# CITY OF PORTLAND, MAINE

## PLANNING BOARD

January 28<sup>th</sup>, 2013

Project Name: **Mixed Use Development at 321 Commercial Street (corner Maple Street)**  
Project ID: 2012-615 CBL: 40-E-3  
Address: 321 Commercial Street  
Applicant: J B Brown & Sons  
Planner: Jean Fraser

SITE PLAN

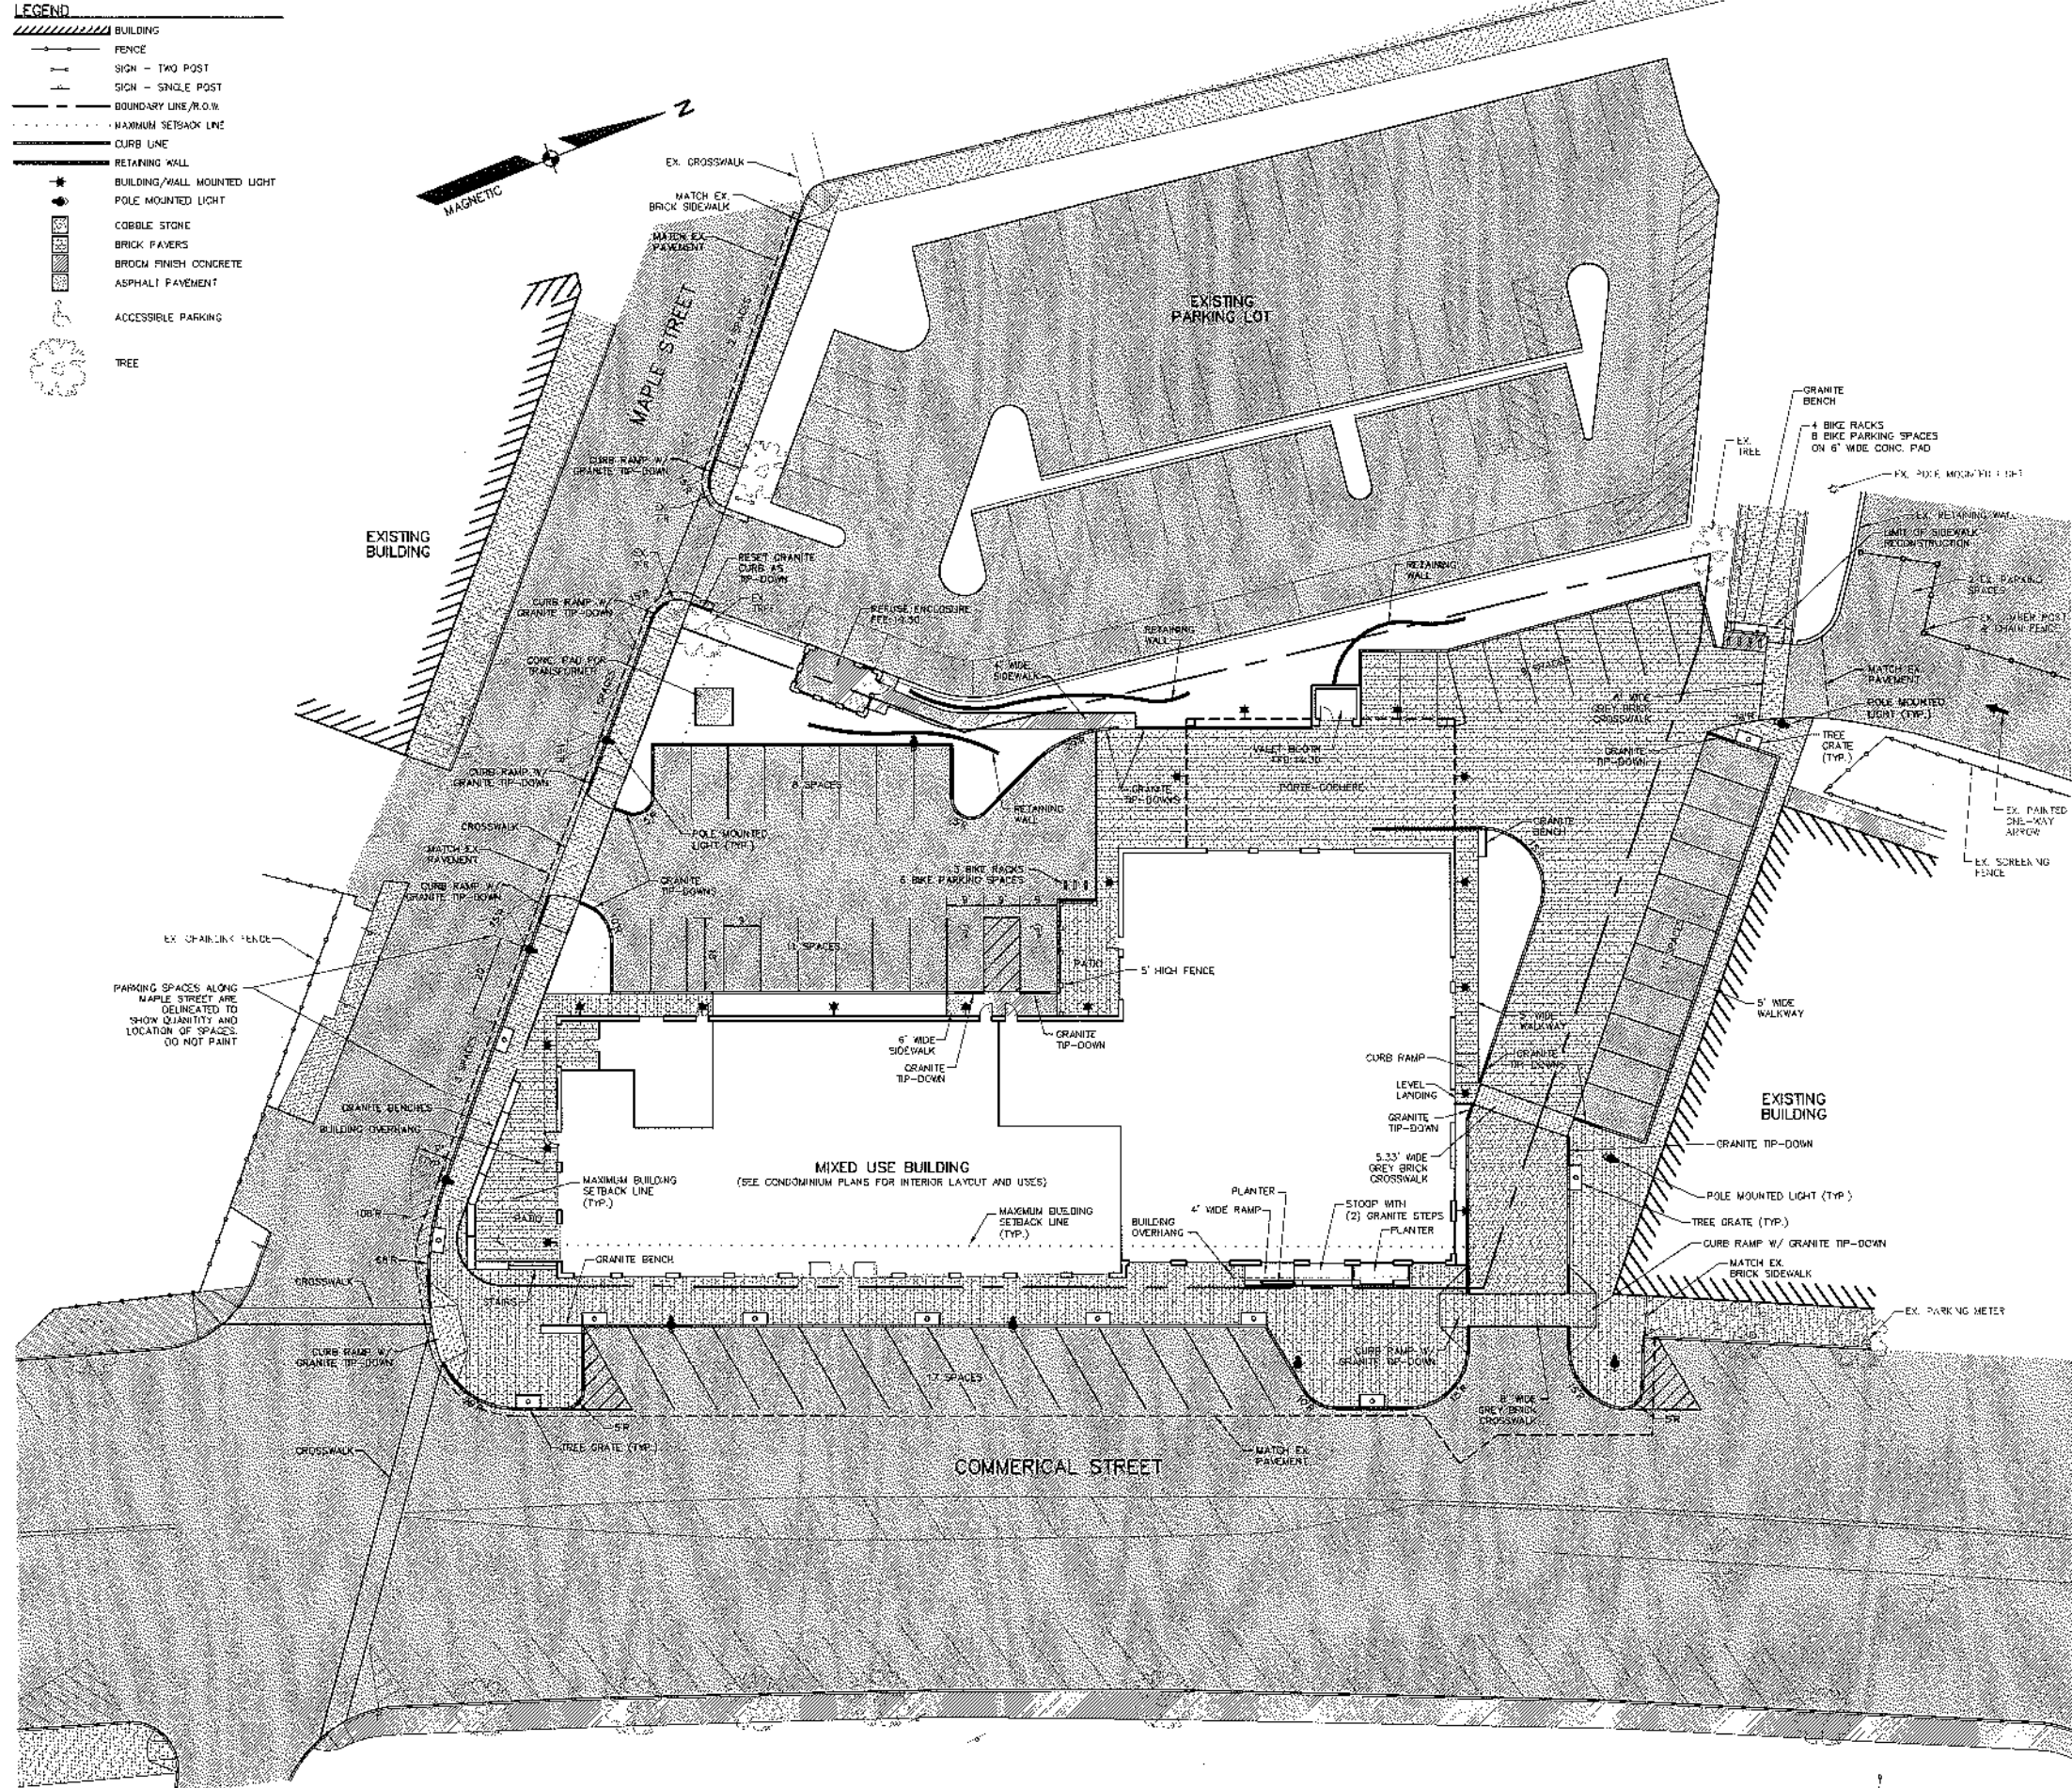
The Planning Board waives Technical Standard, Section 1.20.1, to allow a reduction in the required sight distance to the centerline of the crosswalk on the east side of Commercial Street, subject to the removal of an additional parking space nearest to the crosswalk, as based on Plan CO4 Rev 1.15.2013.

\* November 9, 2012 Comment: The applicant has illustrated a proposed crosswalk on Commercial Street at the easterly corner of Maple Street. I need to review this proposal. My general sense is additional features are needed for safe pedestrian crossing. I would also note that the alignment of the crosswalk on the site plan will need to be adjusted to meet the City's perpendicular alignment design preference. The crosswalk paint detail would also need to be "Block" style.

**Status: I support the proposed crosswalk on Commercial Street with the following suggested changes. I would further note that this crosswalk was reviewed by the City's Crosswalk Committee and the Committee provided conditional support. Final approval of the details by the Committee will be required:**

- o **The Commercial Street crosswalk shall not intersect the Maple Street crosswalk at an "apex" location. Separate crosswalk ramps shall be constructed on the project site corner. This change may require some adjustment to the proposed stormwater planter.**

- o **For improved safety it is suggested that an additional parking space be eliminated on Commercial Street abutting the proposed crosswalk. Accordingly, the striped island will need to be expanded.**
- o **The applicant shall install crosswalk warning signs that meet standards in the MUTCD.**
